STATE OF NORTH CAROLINA
DEPARTMENT OF TRANSPORTATION

Addendum No. 1

RE: Contract # C204286

I-40 FROM THE TENNESSEE STATE LINE TO MP-15

PROJECT REFERENCE NO.		SHEET NO.
L-5922	L-5923	2A-1
STATE PROJECT	F.A. PROJECT NO.	DESCRIPTION

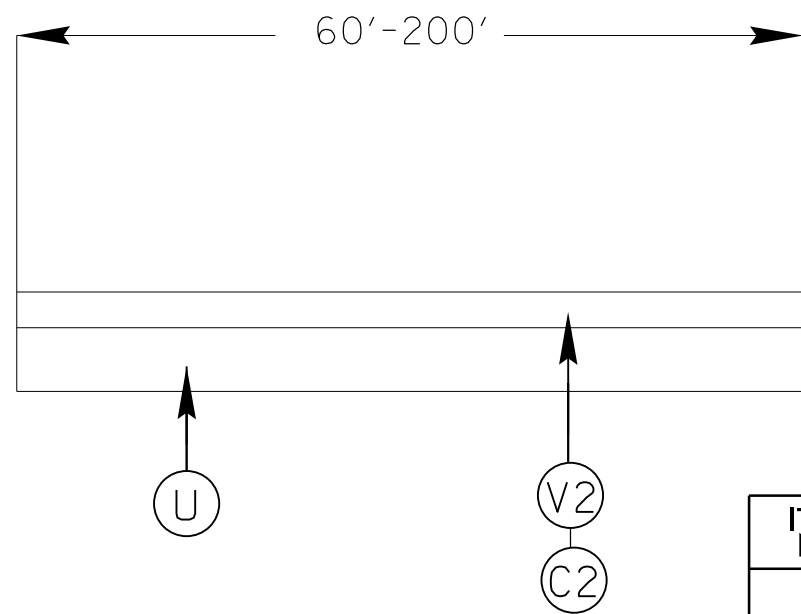
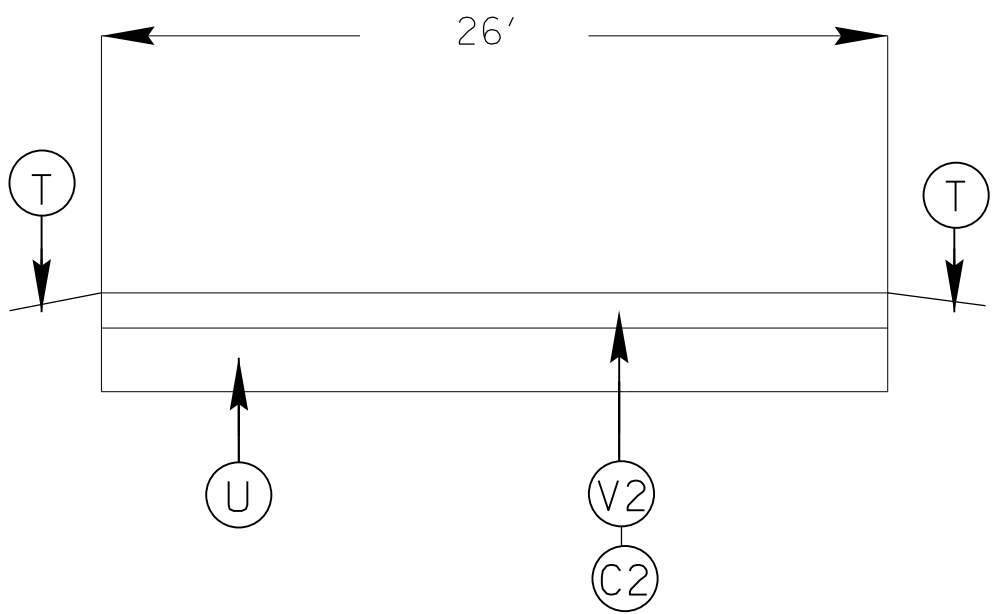
Sheet No.	Revisions
2A-1	Typical #1 revised to depict existing OGAFc layer and a note added.
